**Ref: Planning application 3/2022/1018 Variation Condition 2 (Plans) of planning application 3/2020/0424. To allow inclusion of two high level windows to the garage.**

Tuesday 15<sup>th</sup> November 2022

name
elevations - proposed

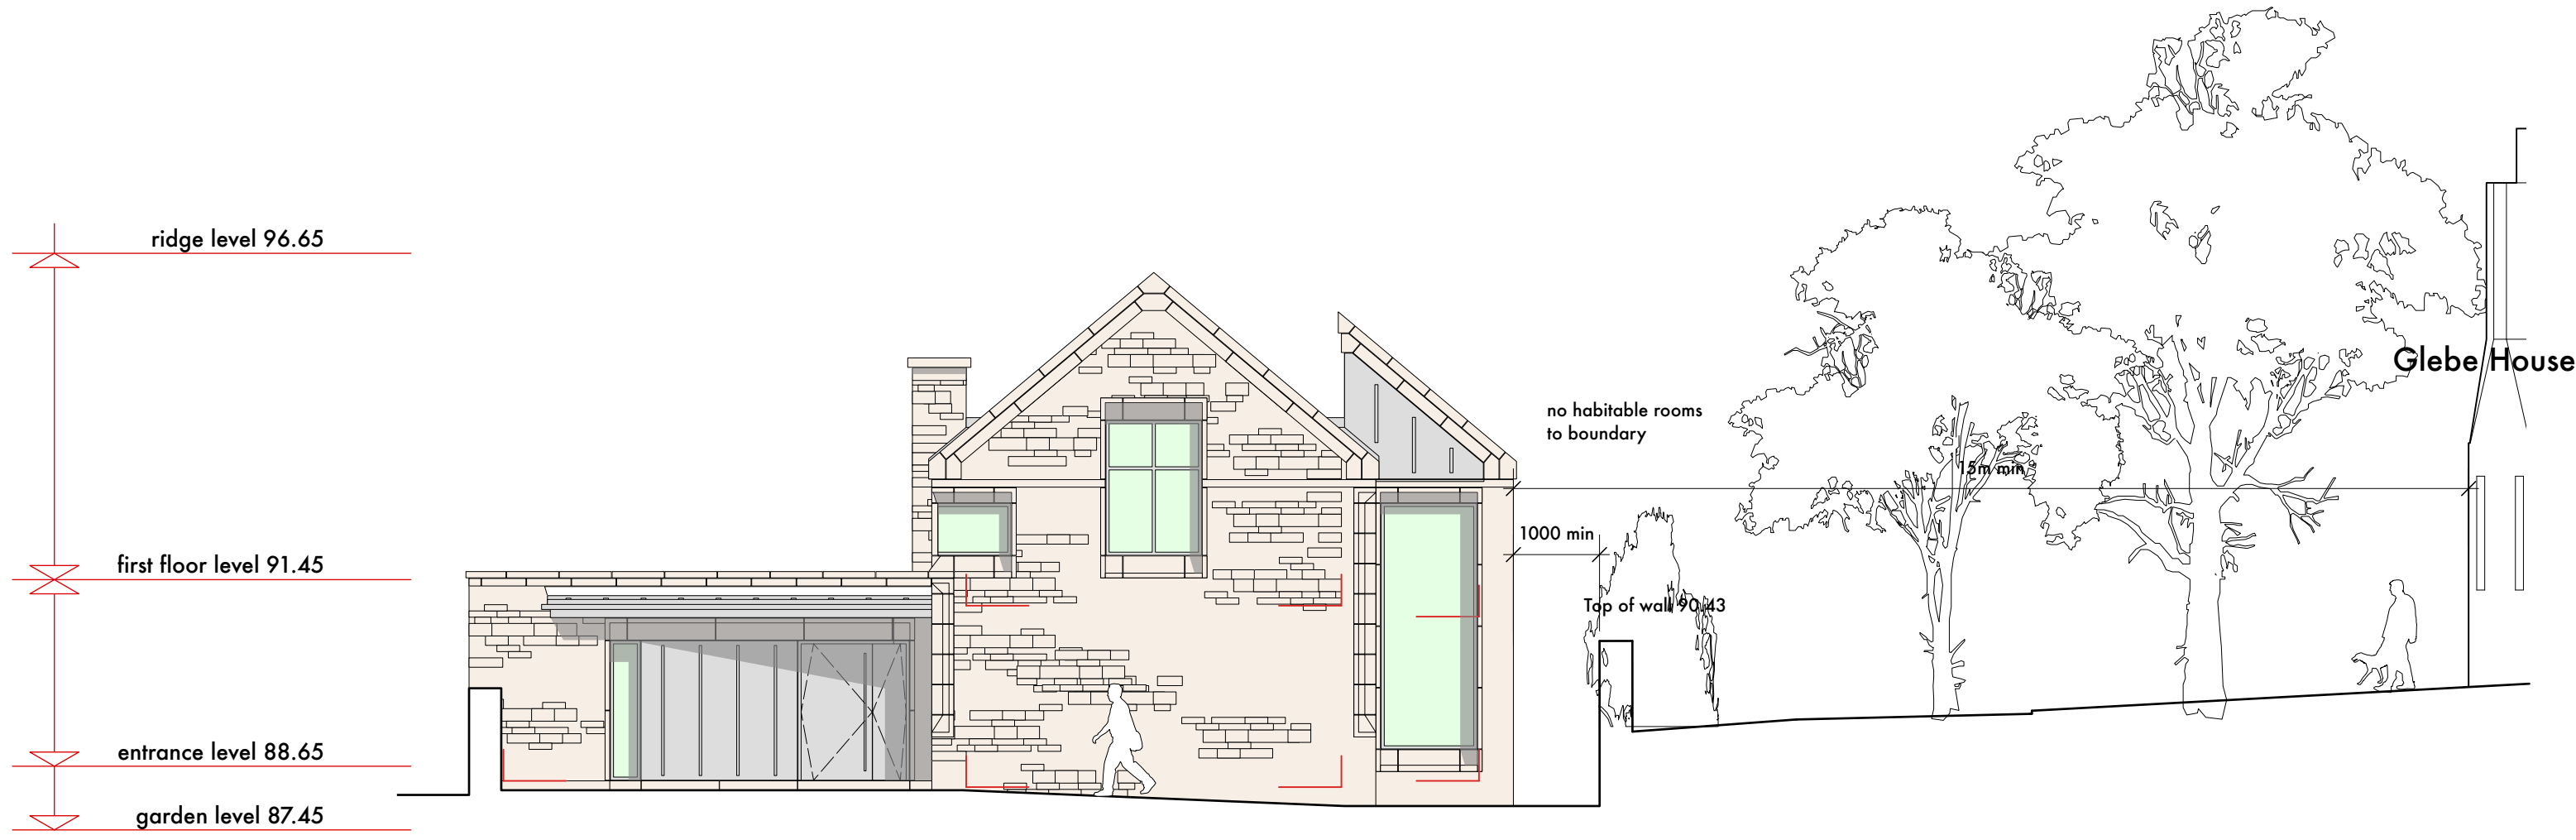
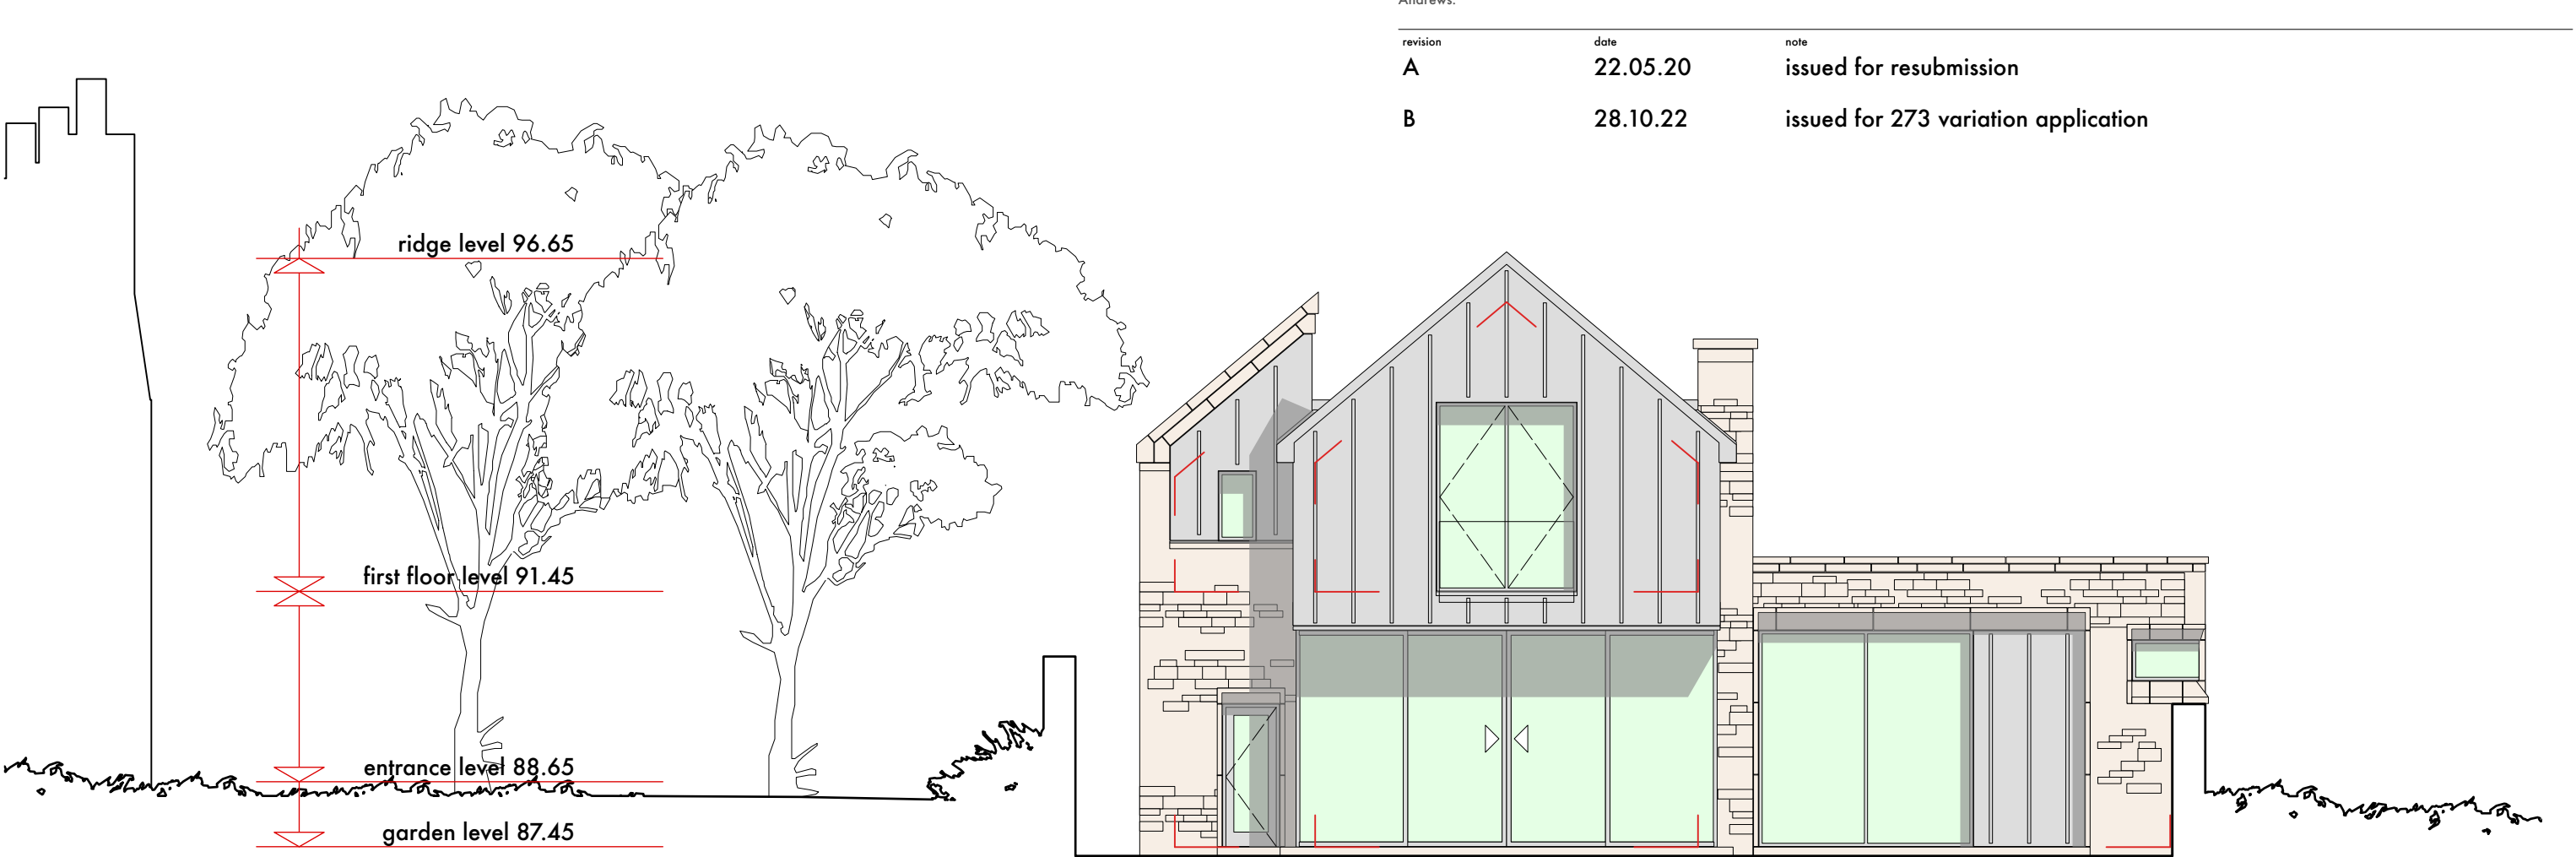
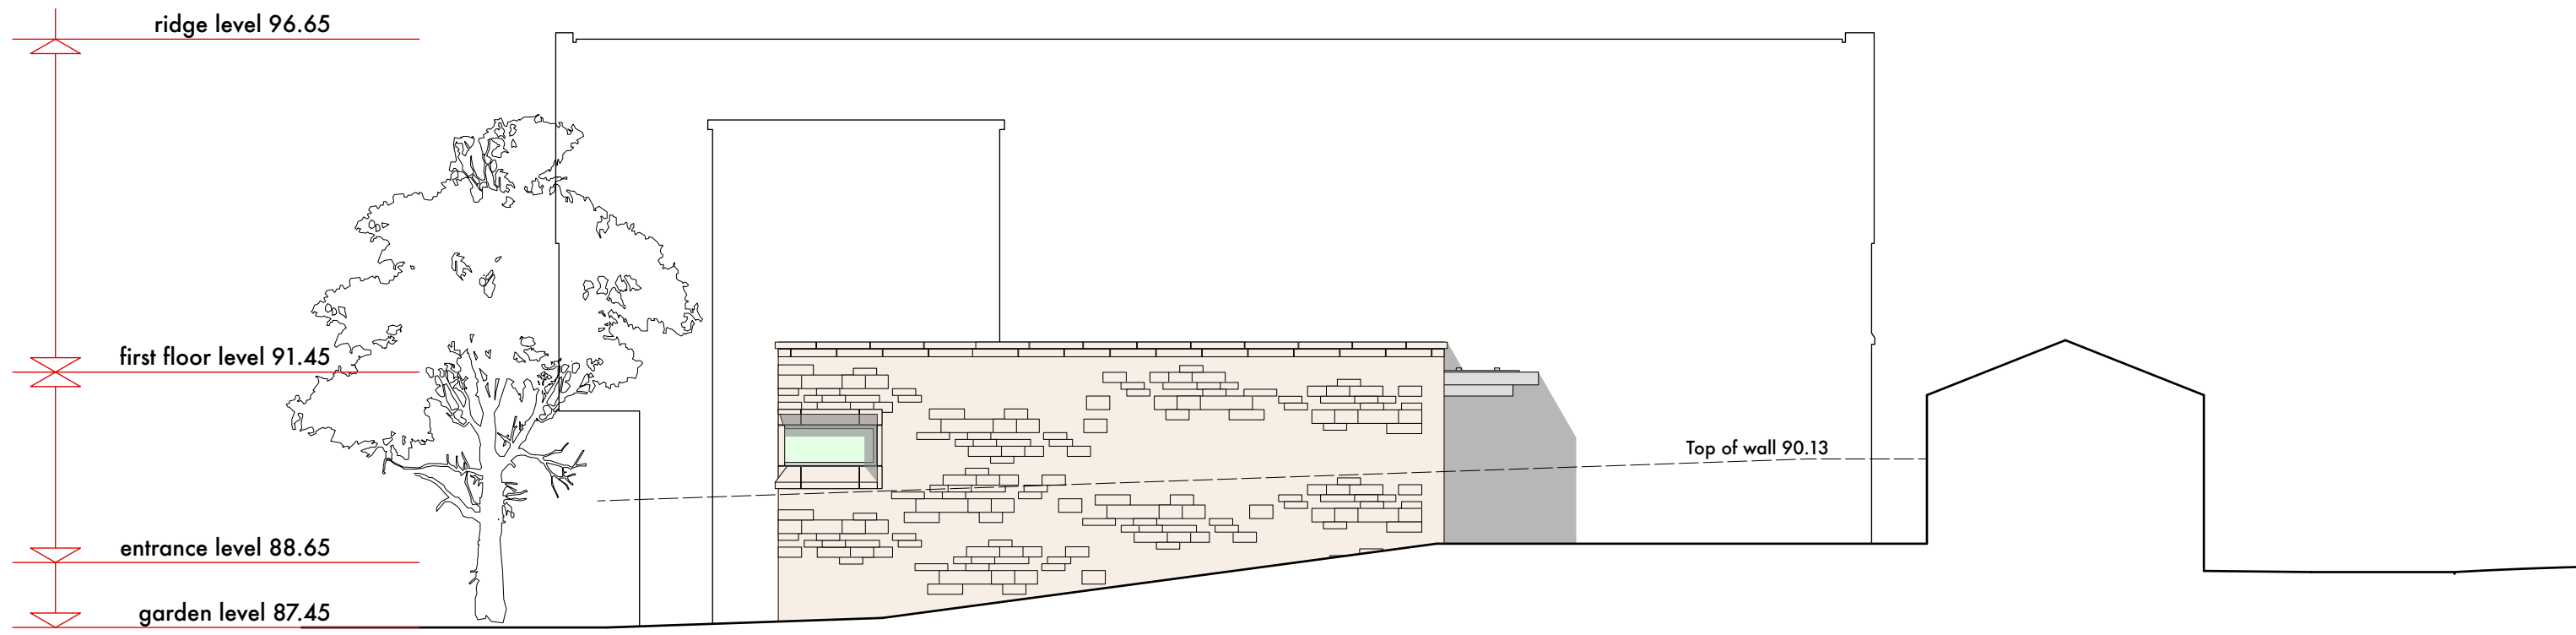
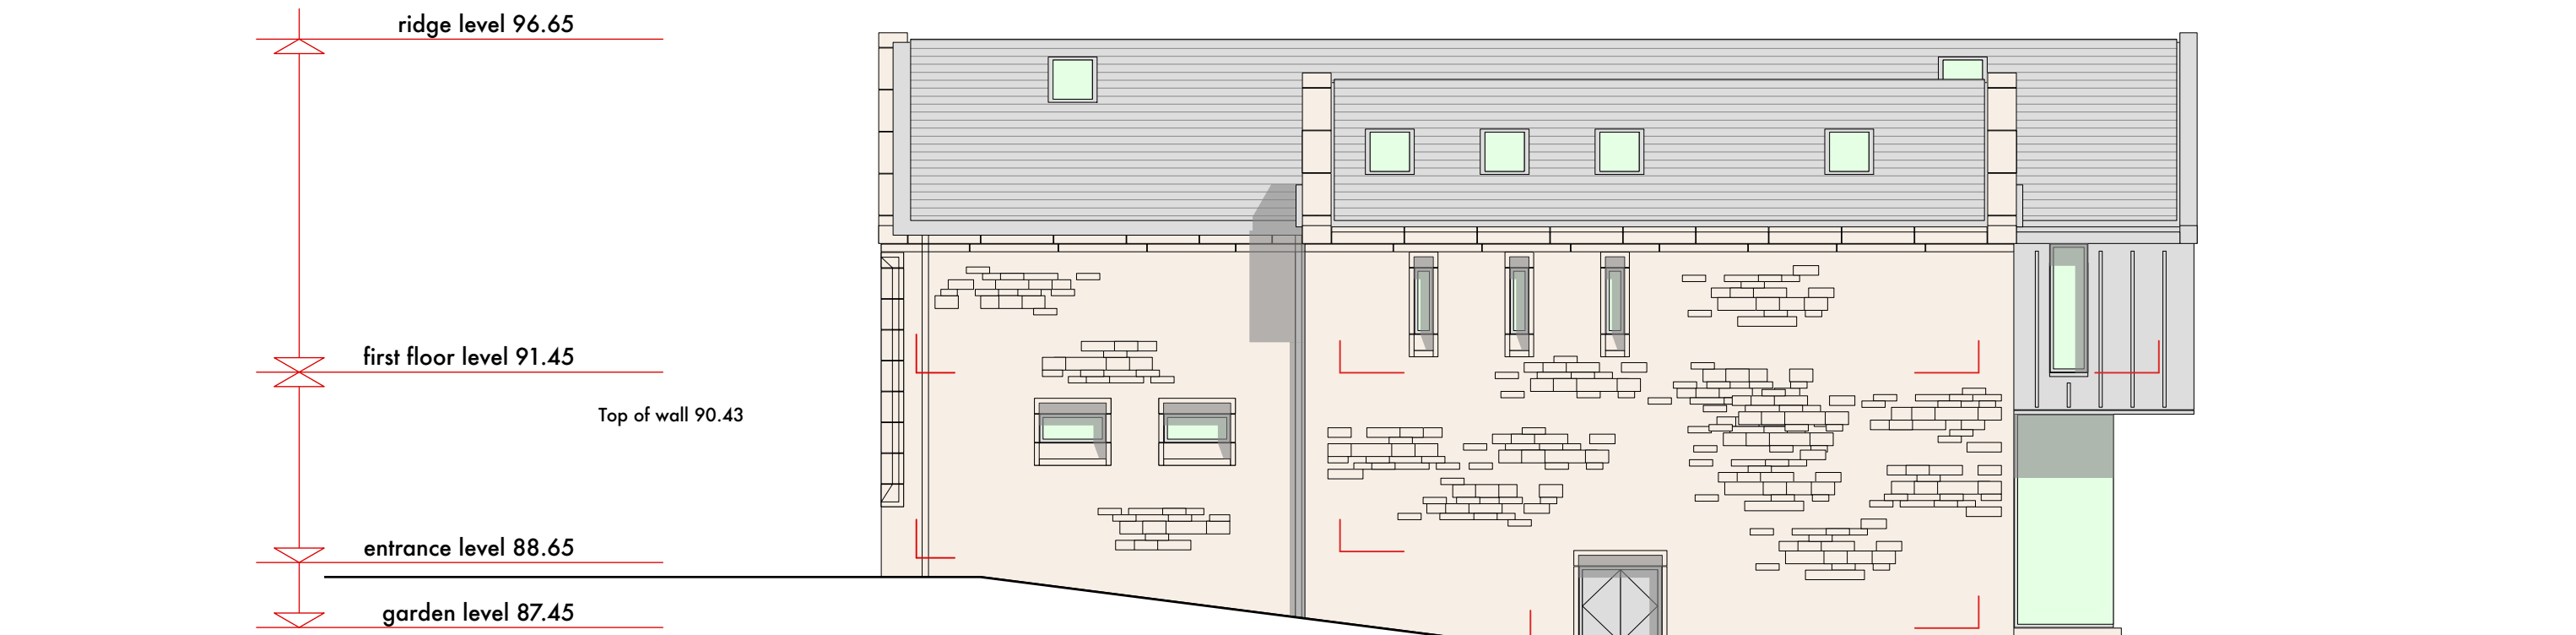
This variation should be a retrospective application as the window openings in the build are already in place? This application also contains a variation in height of the proposed development. The ridge levels approved under planning application 3/2020/0424 were 96.30 and now on these amended plans they appear to be 96.65. The property has already been built to this level. Surely by approving this application you are setting a dangerous precedent by approving plans after the changes have already been made.

The scale of the plans do not appear to match what has been built and we would ask enforcement to check the height of this development and resubmit the drawings at the true scale of the development.

- The size of the proposed two storey dwelling that has been constructed has not been approved and is out of scale with the plans approved.
- The size is unsuitable and is having a detrimental effect on Waddington Conservation Area.
- Neighbouring properties are now suffering from loss of light and privacy by the raised elevation of the development and the addition of windows.
